## Application for a Non-Material Amendment Following a Grant of Planning Permission

Erection of a single-storey extension to the side, first floor extension to the rear, Juliet balconies, rooflight, uPvc windows and doors to side and rear, creation of 2no. vehicular parking spaces, and replacement outbuilding to the rear

23/00313/FL

Change of the side and rear elevations of the proposed extension from brick facades to render facades with brick corner detail

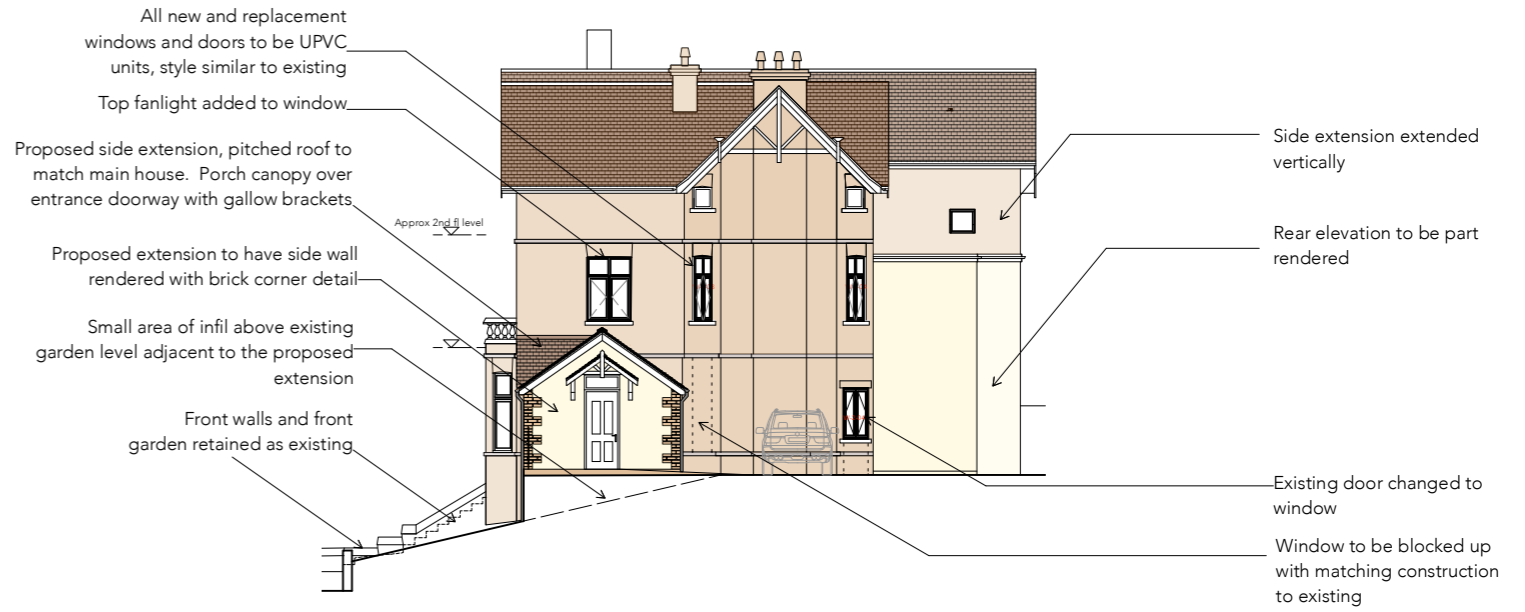
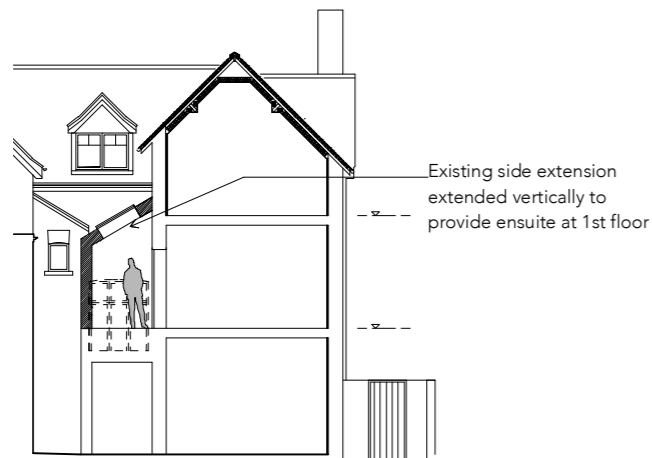
We managed to source original 'Grosmont' bricks to match the main house but not enough to use for the whole extension. These bricks are larger than modern bricks so it is not possible to use modern bricks instead. The rear of the property is to be rendered so the changes would match the rest of the building.

134 P06 Rev H Proposed Elevations
